Application: SSI 7485

I write regarding the proposed modification to M4-M5 Link, Mod 2 The Crescent overpass and changes to pedestrian infrastructure in North Annandale, Rozelle and Rozelle Bay Foreshore area.

Figure 4-2 Pedestrian and cyclist bridge infrastructure options

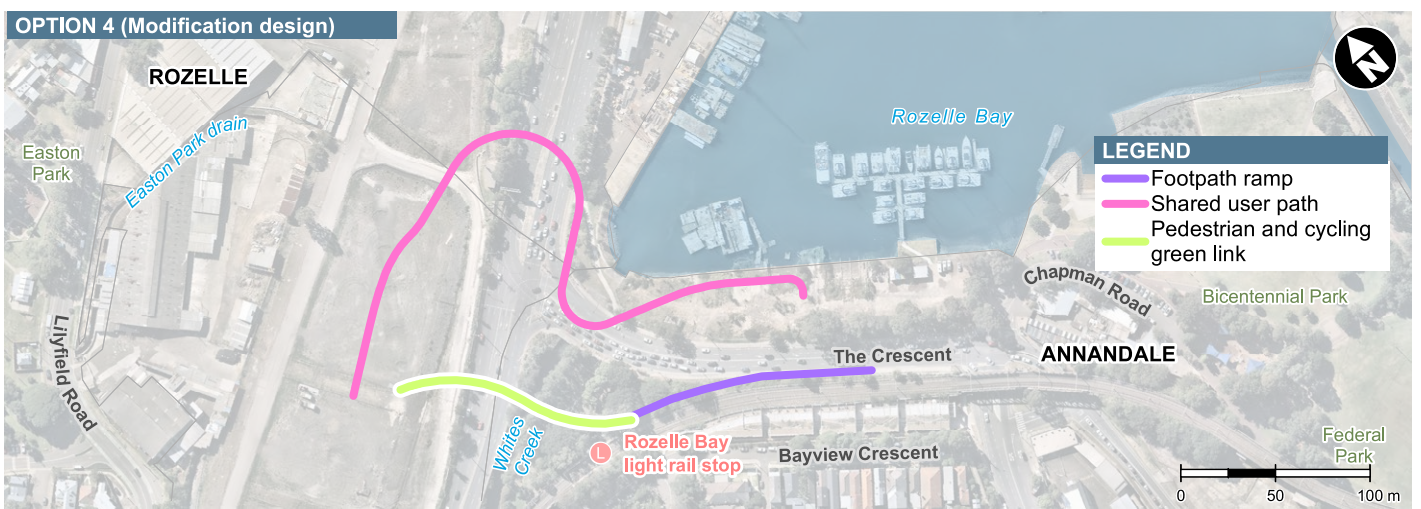
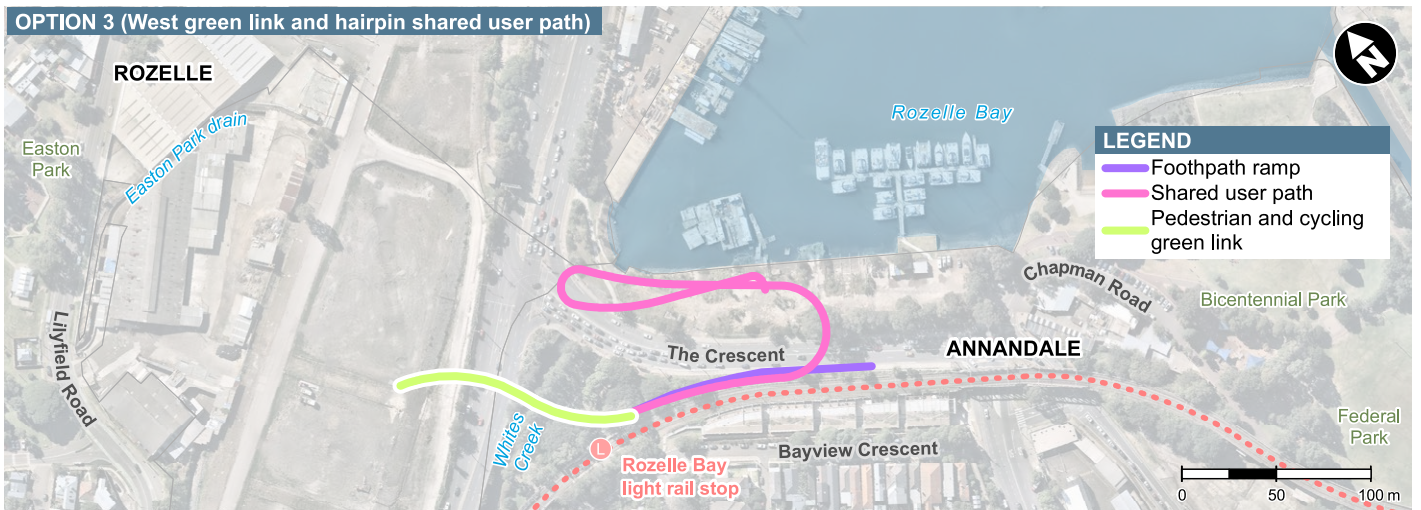
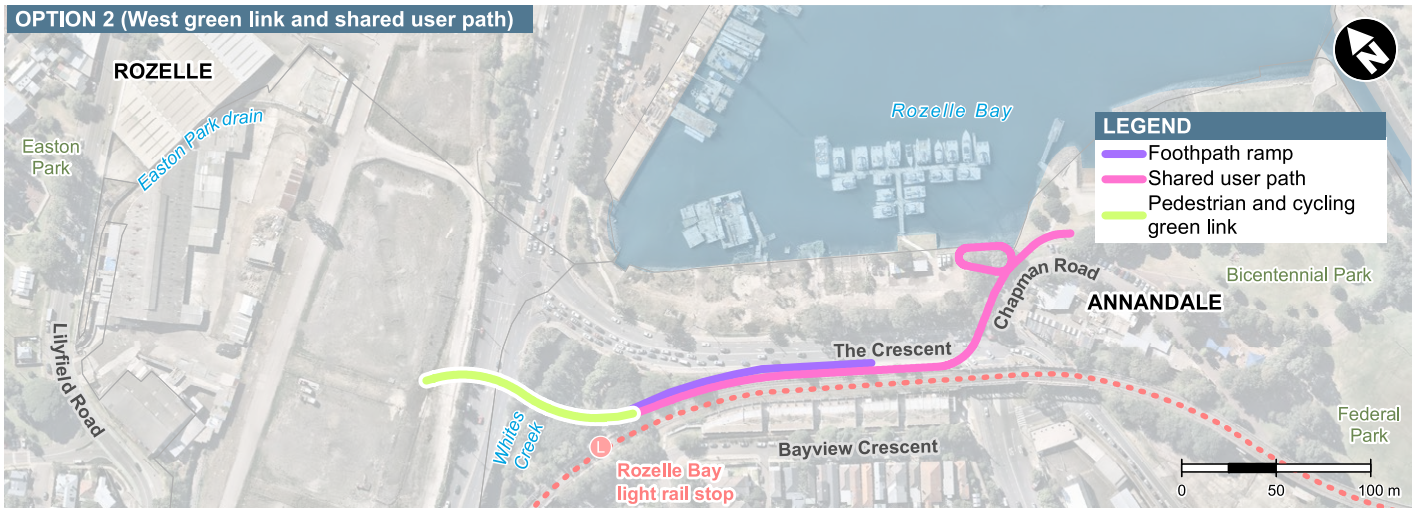
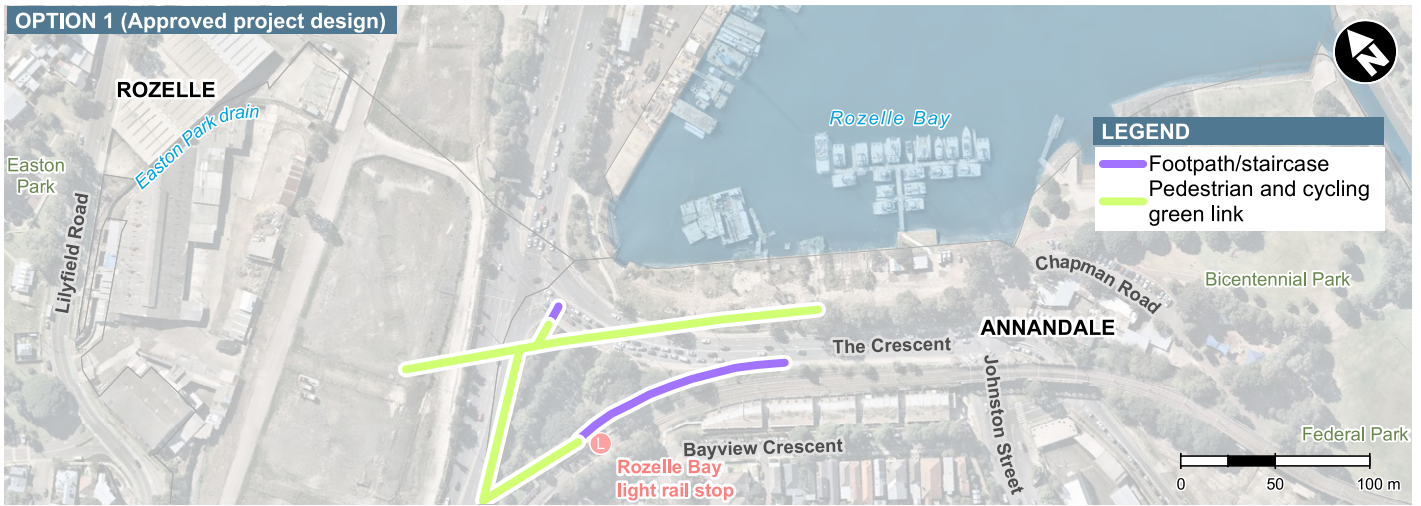
I request RMS work with the community to explore alternate design options to the proposed new car overpass design and the changed pedestrian and cyclist links. I am seeking the reinstatement of the safe, direct access from the approved EIS GreenLink to create a continuous green open space connection from the Rozelle Rail yards and Annandale to the foreshore. The GreenLink was more than just a walk way - it put people central to the design, maximising safety, and providing much needed accessible open space for the community now and into the future Bays Precinct design.

- The significantly reduced safety and increased risk for pedestrians and cyclists with removed access over The Crescent to Bicentennial Park and the increased traffic along Johnson Street.
- Being required to cross five sets of pedestrian lights at The Crescent as my option to reach the foreshore from Annandale or from Rozelle Bay light rail stop.
- Removal of direct active links to the foreshore, cutting the community off from the area and the proposed revitalisation of the entire Bays Precinct, including linking the Light Rail and Bus stops to a Ferry wharf and Metro station.
- Urban and landscape design that is being built before a finalised Masterplan for the area.
- Traffic changes that limit movements around the suburb and create further congestion in the local streets of Annandale, Forest Lodge, Glebe, Lilyfield and Rozelle with no planning to deal with these.

- Reinstate the GreenLink connecting communities and green open space from Rozelle to Bicentennial Park
- Relocate and design pedestrian and cyclist connections that are continuous, safe and direct.
- Design the modification infrastructure and active links in response to the character of the suburbs, the location of the foreshore and it's potential future development.
- Provide pedestrian and cyclist paths that maximise people safety and do not force them onto busier streets, unsafe concrete plazas and caged walkways.
- Integrate active and direct connections to all active transport - including the future Metro West and Foreshore Ferry Wharf

Figure 4-4 Elevation: Indicative view of The Crescent overpass

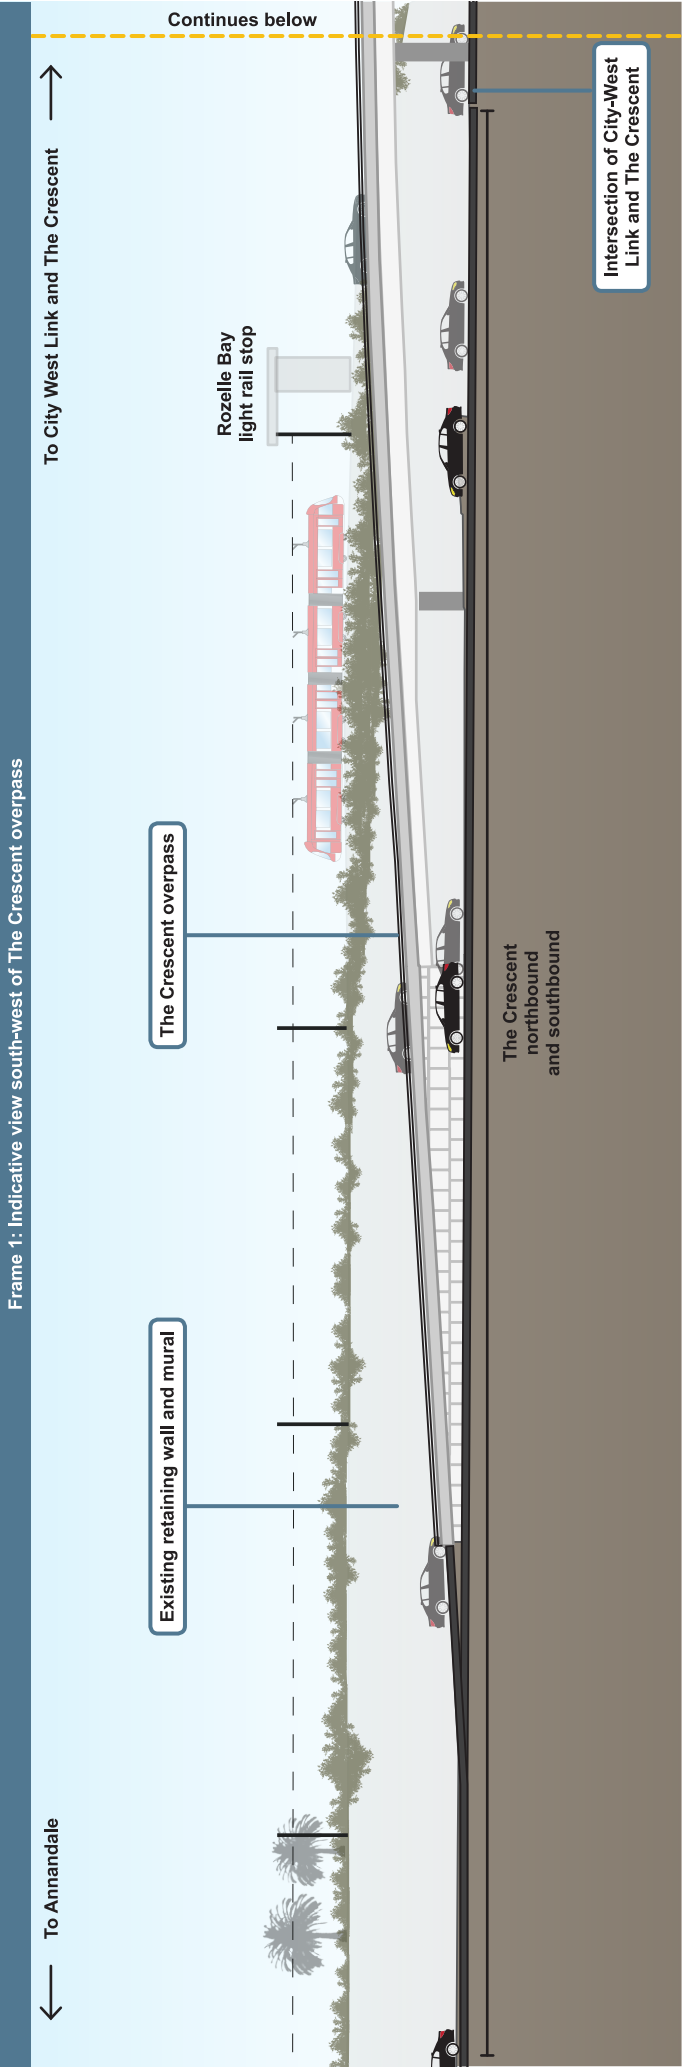
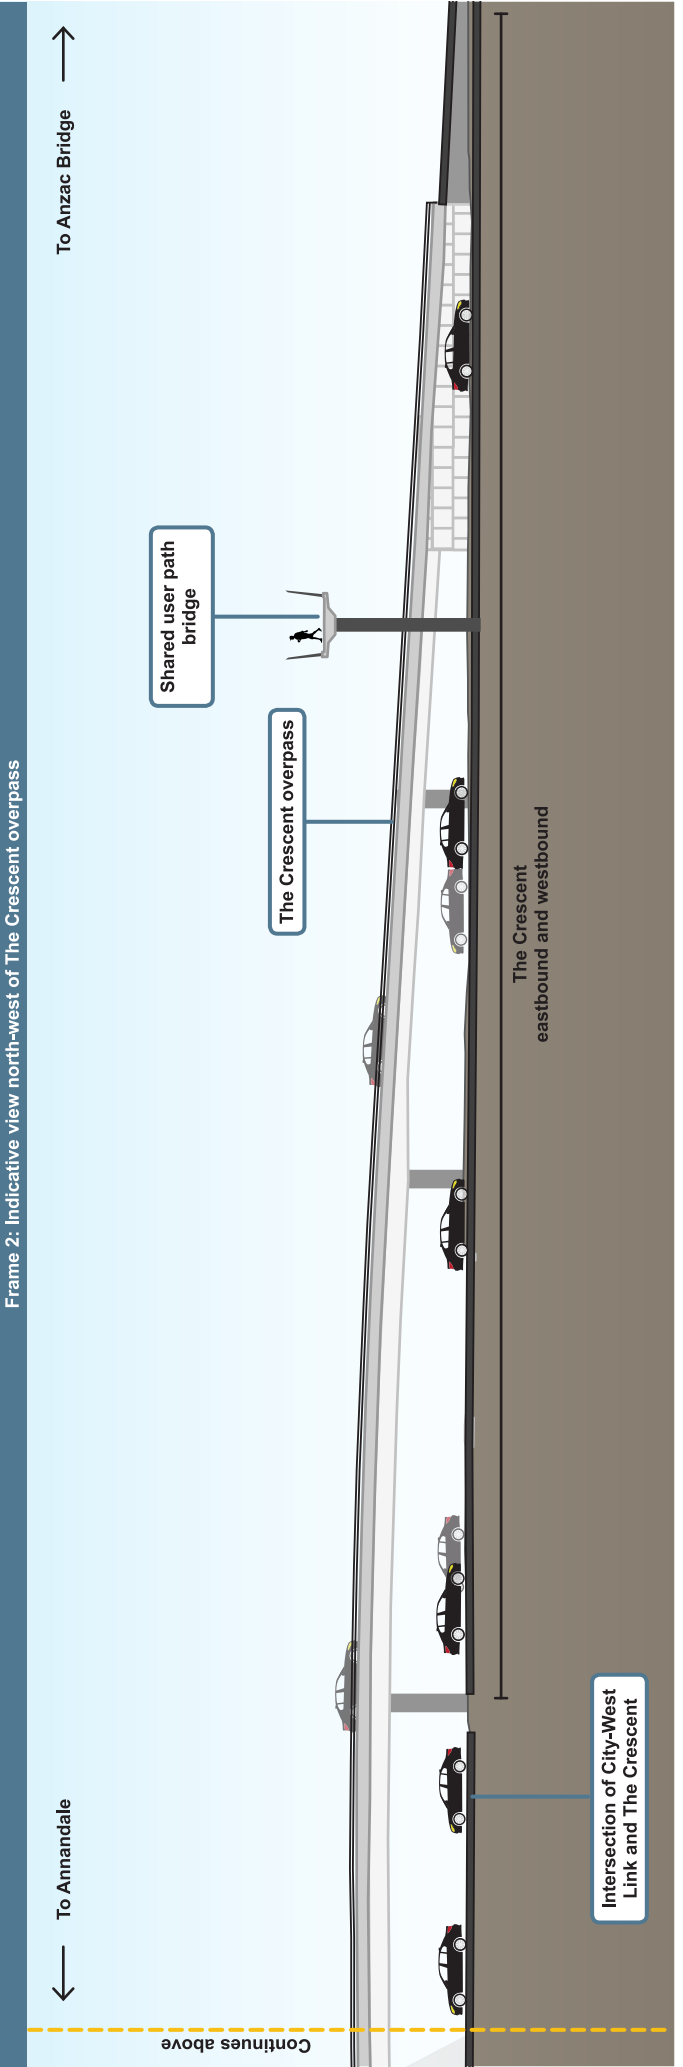
Elevated roadway cause visual intrusion to this scheme where most of the proposed road system is below ground. We require seamless connection for people from Rozelle to the Annandale side so that roads do not need to be crossed at traffic lights. This is the most safe alternative for pedestrians considering this major road system. Connection the bay to the new park lands is crucial to the success of this project.

- Outdated elevated roadways be scrapped. They are visually polluting and a blight on the landscape.
- This overpass will just encourage more traffic into and out of Annandale and should be scrapped.
- The whole of the Crescent and City West Link Intersection should be underground and covered by elevated landscape platforms seamlessly connecting to the Bay Area.
- Active pedestrian and public transport options should be priority in any transport system. No cars & trucks taking centre stage as proposed by the whole West Connex juggernaut eating up our suburbs.
